Recommendation Report for Planning Permission for Works or Extension to a Dwelling

REF NO: AW/58/19/HH

LOCATION: 2 Stirling Way
Aldwick
PO21 4PN

PROPOSAL: Single storey extension.

PROPOSED ELEVATIONS

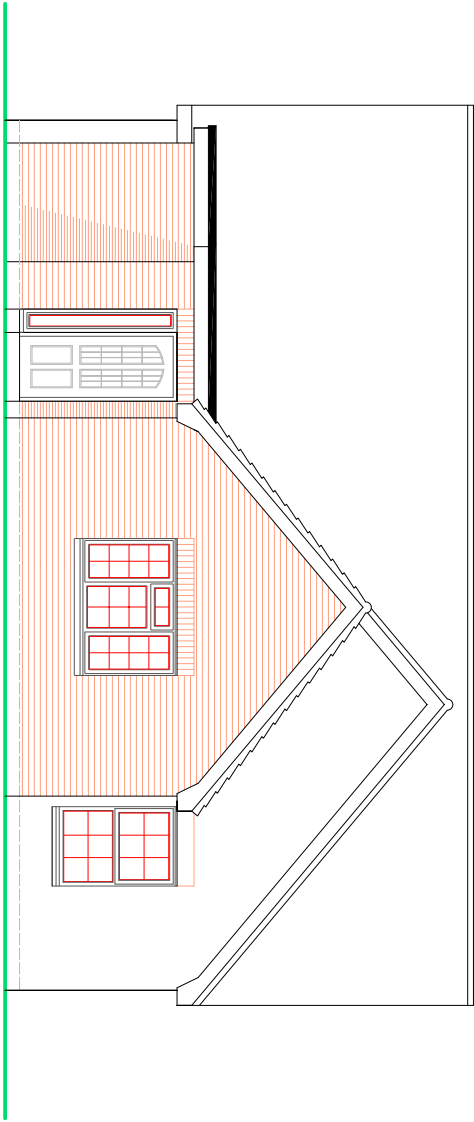
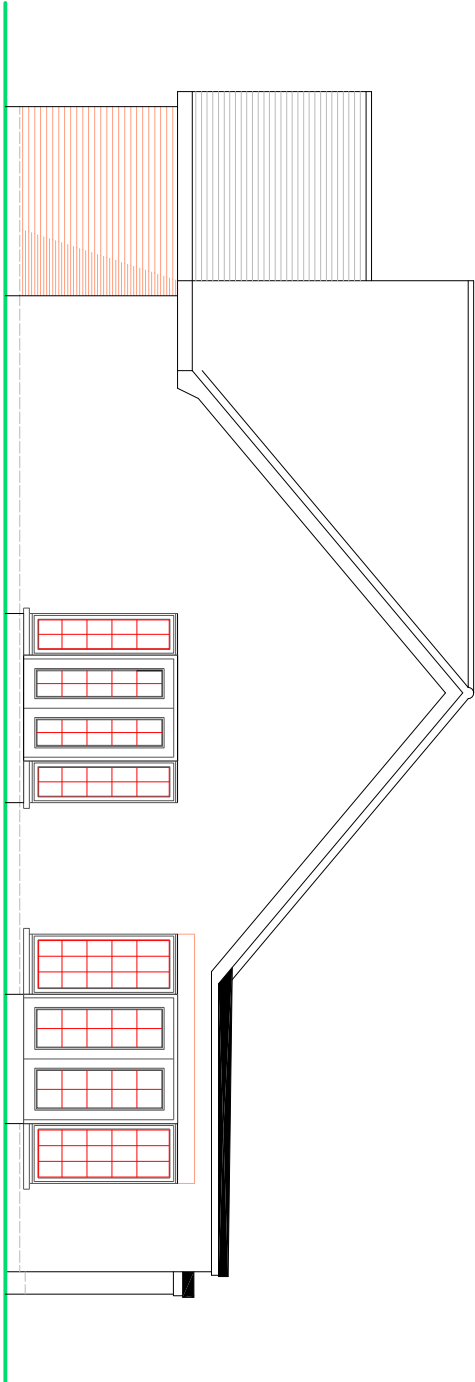
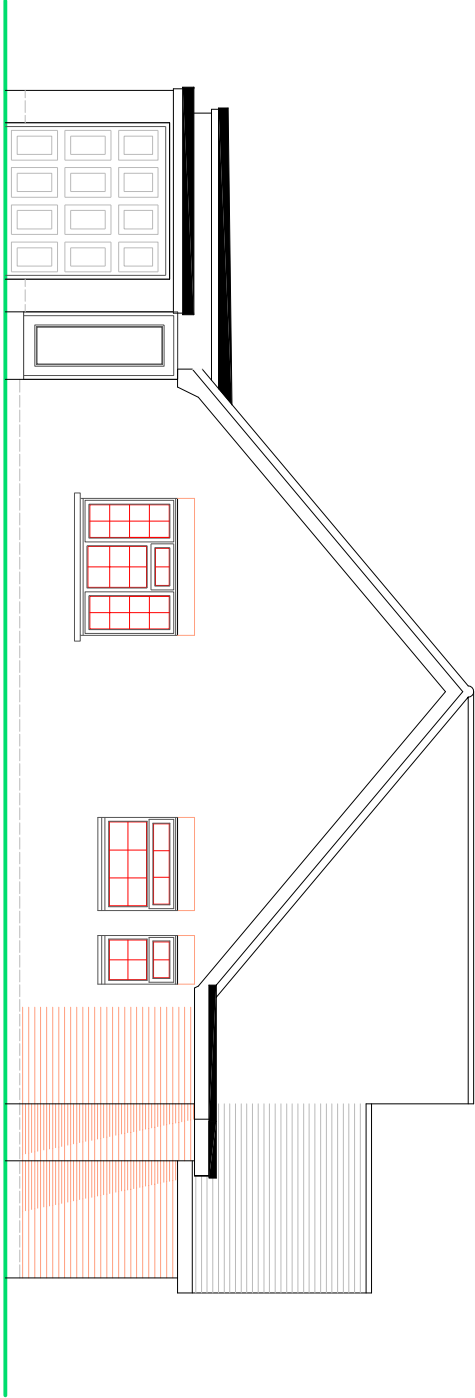
The proposed side extension will measure approximately 8.6m in length, a maximum of 2.5m in width at the largest part and be built to a height of 4.8m. The extension is considered a modest addition to the dwelling and given its staggered approach and mix of flat roof and pitched roof will not have a detrimental impact on the character of the host dwelling or the street scene. The surrounding properties are of a mixed design and style and as such the proposed development will not appear out of character with the locality.

The proposed side extension will be located approximately 2.4m from the Northern boundary, 3.8m from the Eastern boundary and 3.5m from the Southern boundary. The proposed extension will feature a door and a window on the Eastern elevation. This proposed window and door are not considered to give rise to any additional overlooking or loss of privacy to the neighbouring properties given they will overlook the remaining side garden of the property and the road (Stirling Road). No windows have been incorporated on the Southern or Northern elevations to further mitigate any potential impact upon neighbouring properties.
